Our Ref: P/47/11/

28th July 2011

Single storey extensions
52 East Front Road Pagham

Thank you for your internet comments made on 27th July 2011 and recorded as follows:

For	Date	Dwg by	Revision
Mr and Mrs Evers	24.05.2011	sk	C
Title	Scale	Project no	Dwg no
PROPOSED LAYOUT, ELEVATIONS AND SECTION A-A	1:50	126	P2

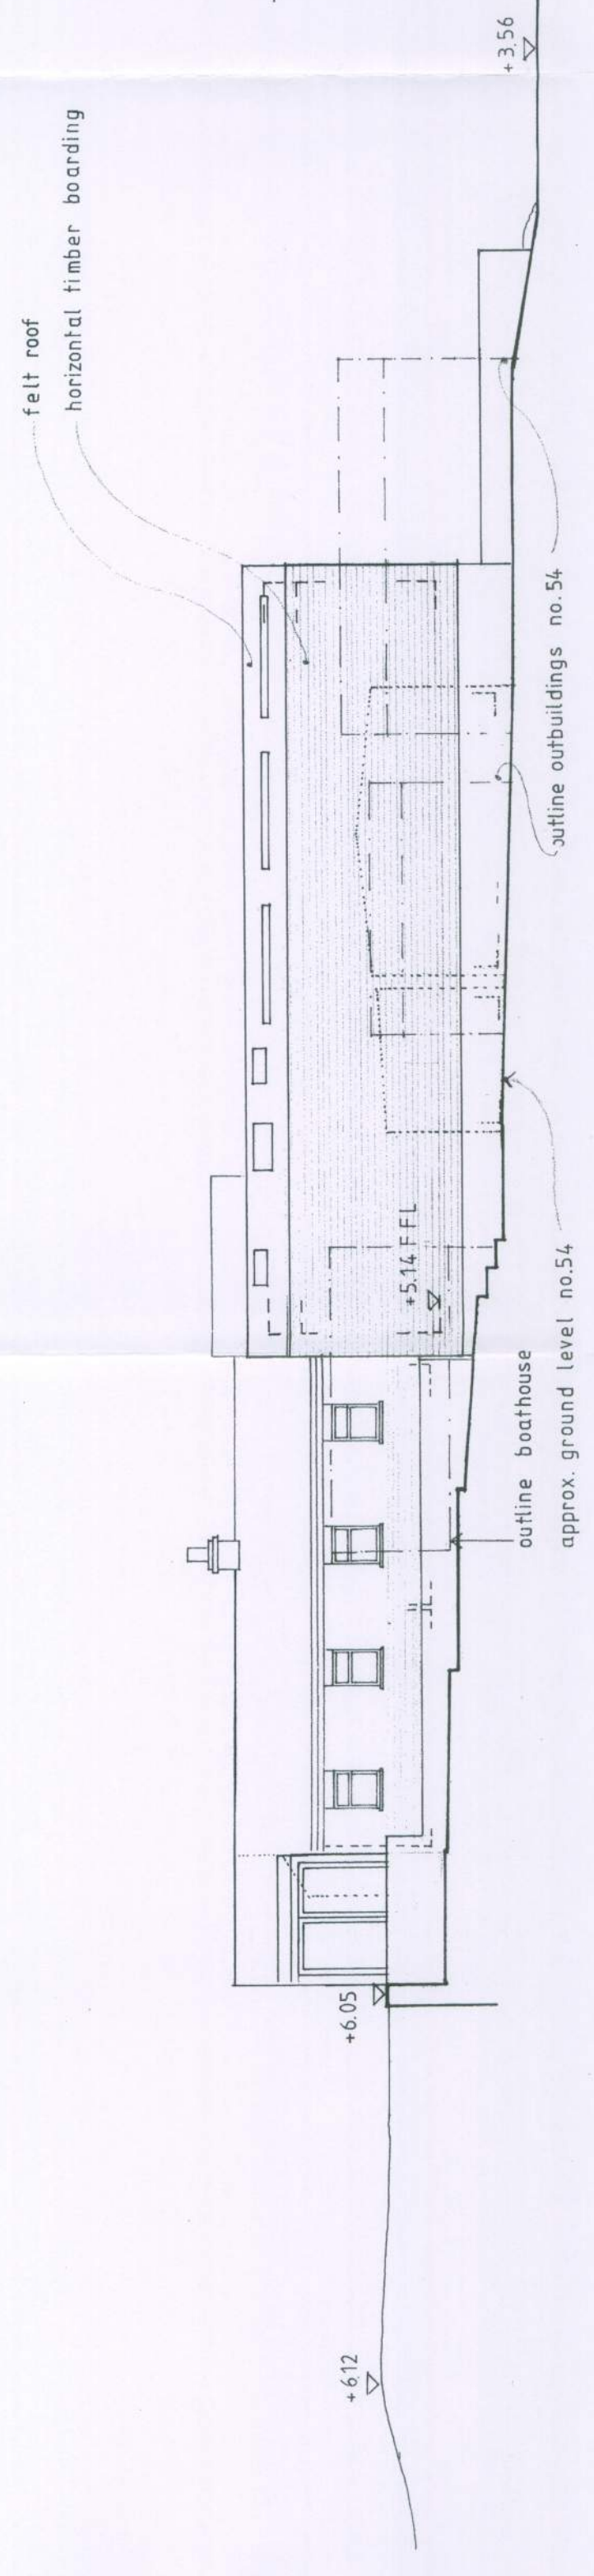
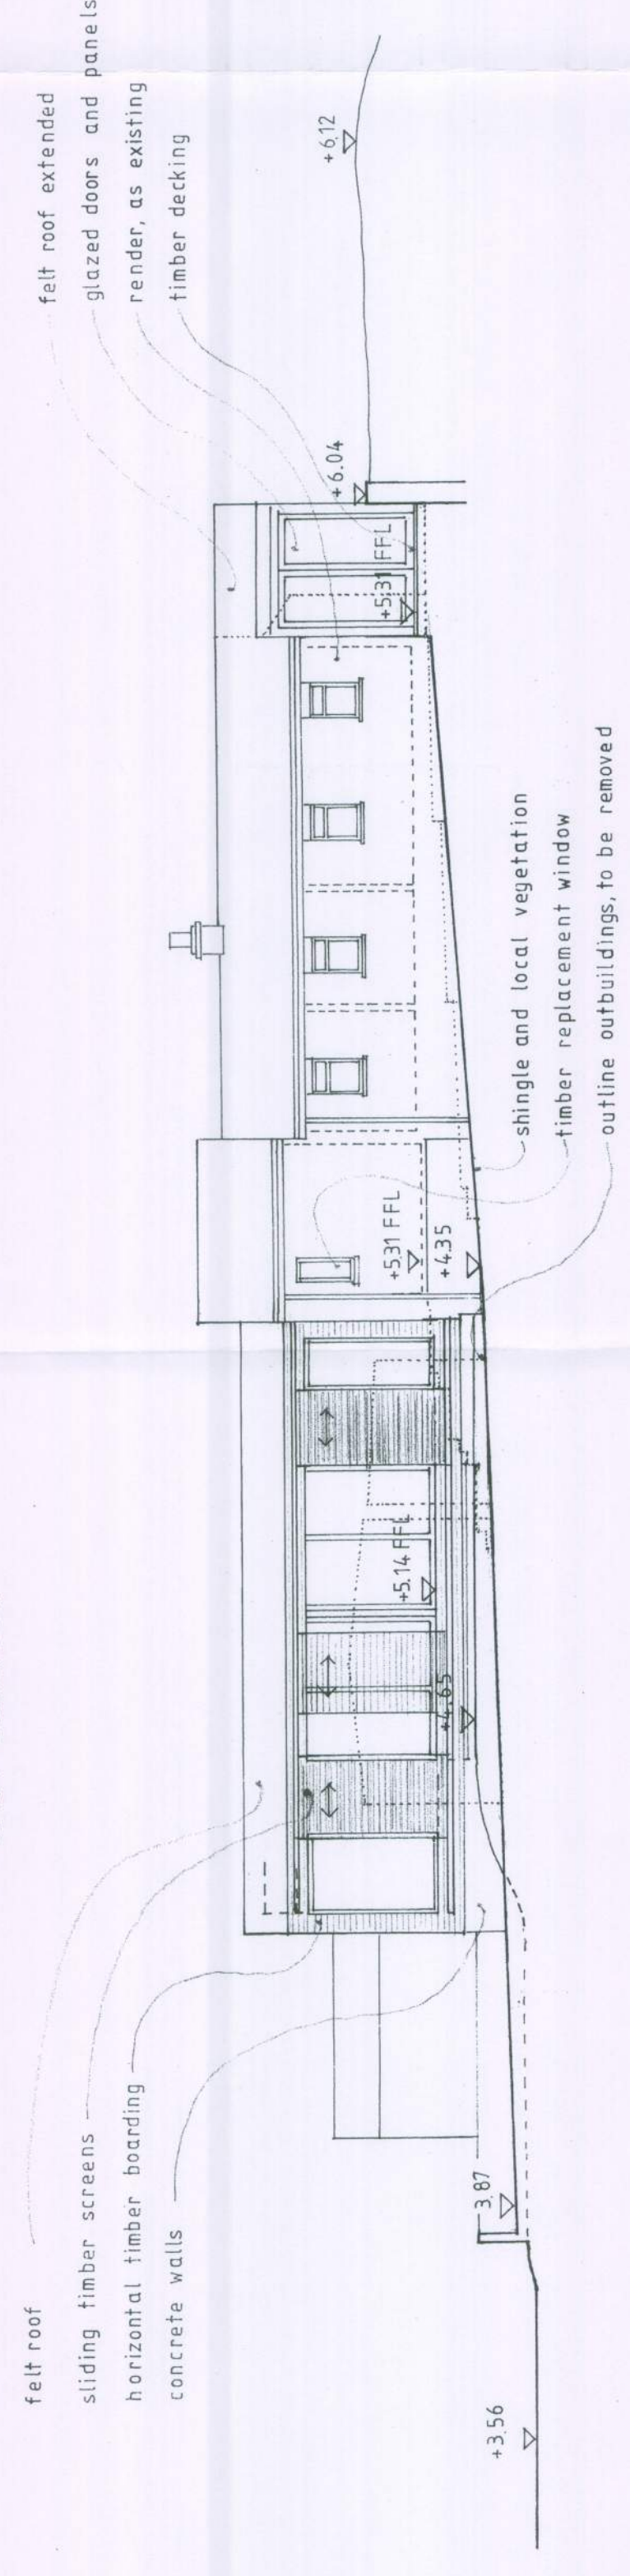
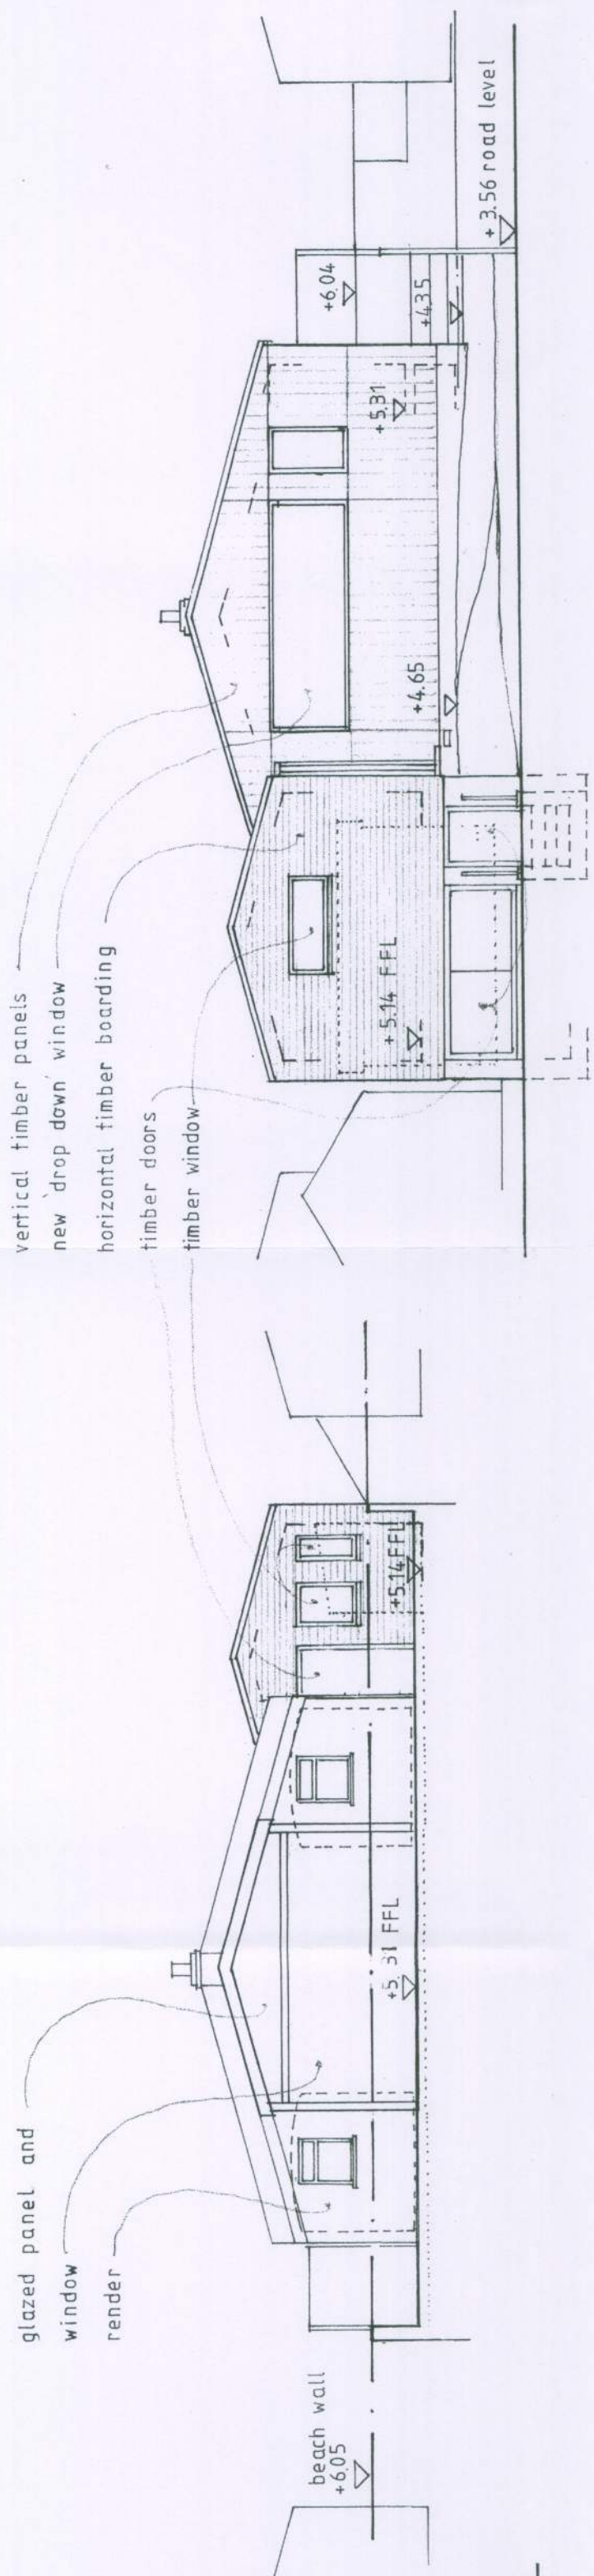
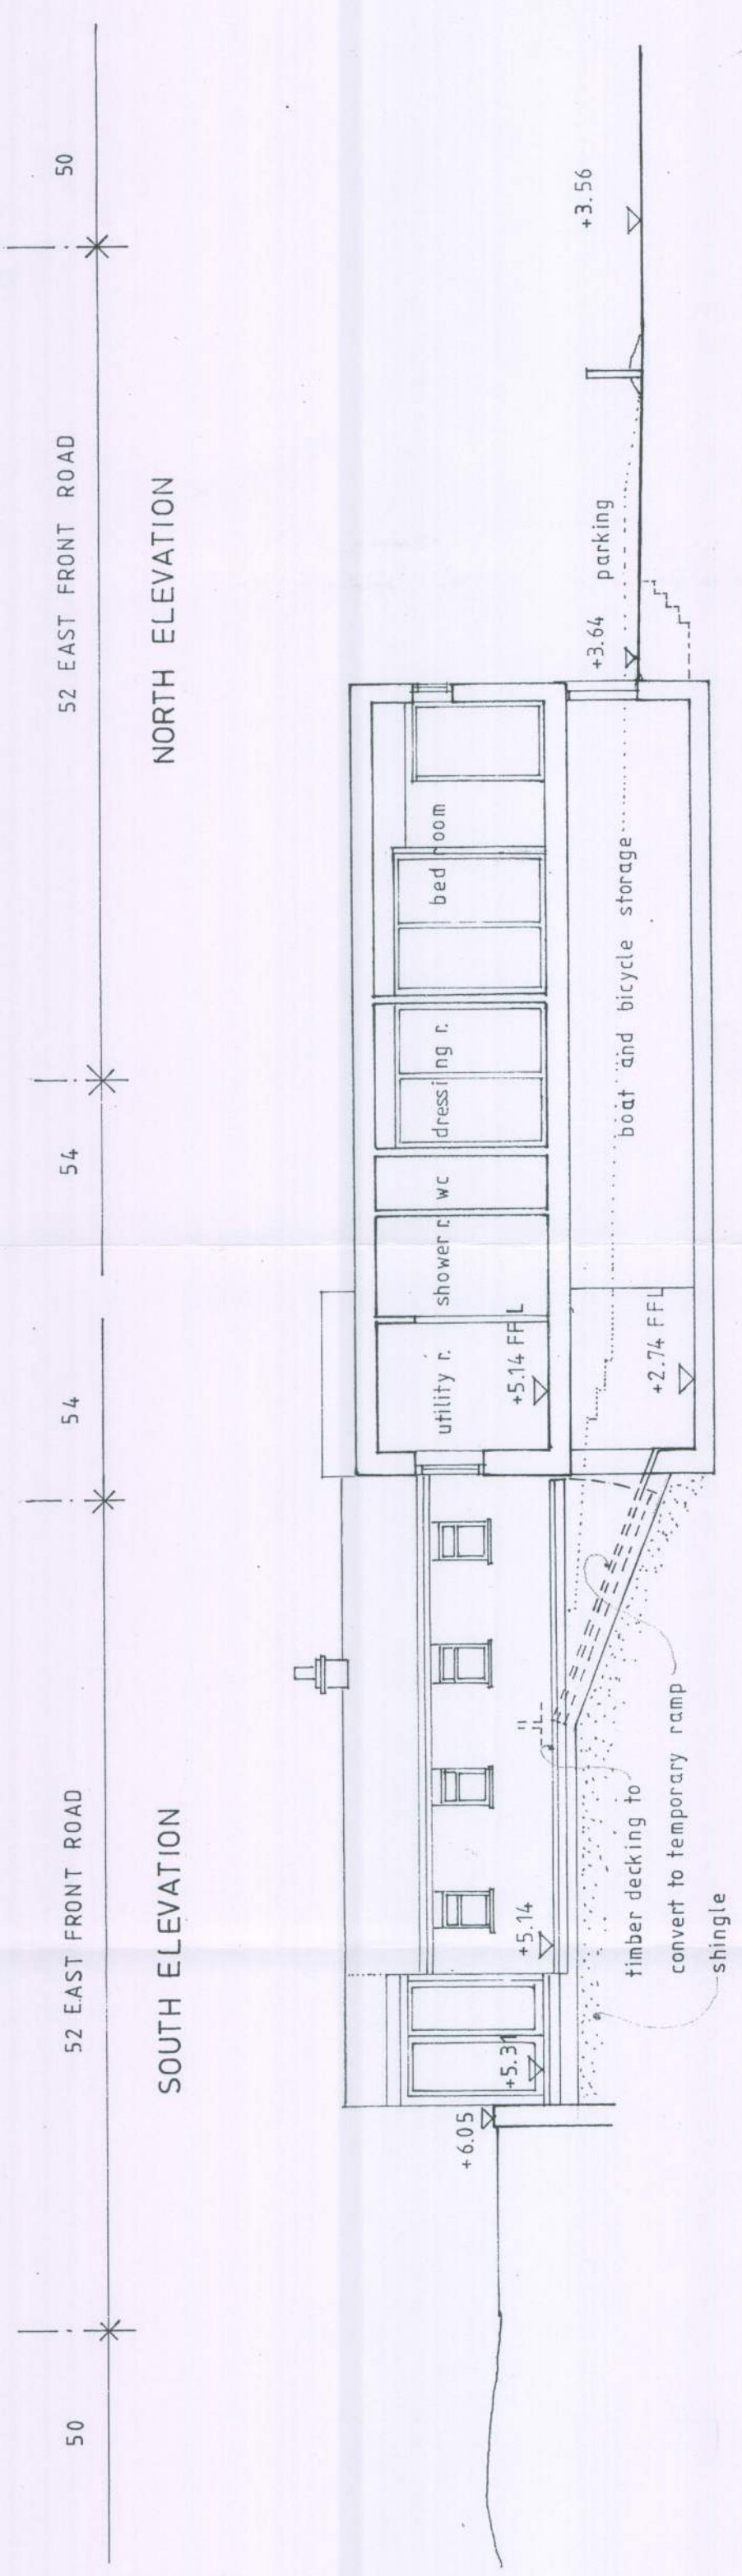
Members felt that this proposal warranted particular scrutiny as it purported to set a precedent for two storey development in respect of which there has been consistent adopted policy constraint since 1975.

Representations from the public have also highlighted the out of character, intrusive and prejudicial nature of recent applications such as this which seek to establish maximum footprint and bulk with little regard to EA recommendations for drainage in a 3a flood zone. Members agreed with these representations that this proposal was dominant and overbearing to adjacent dwellings.
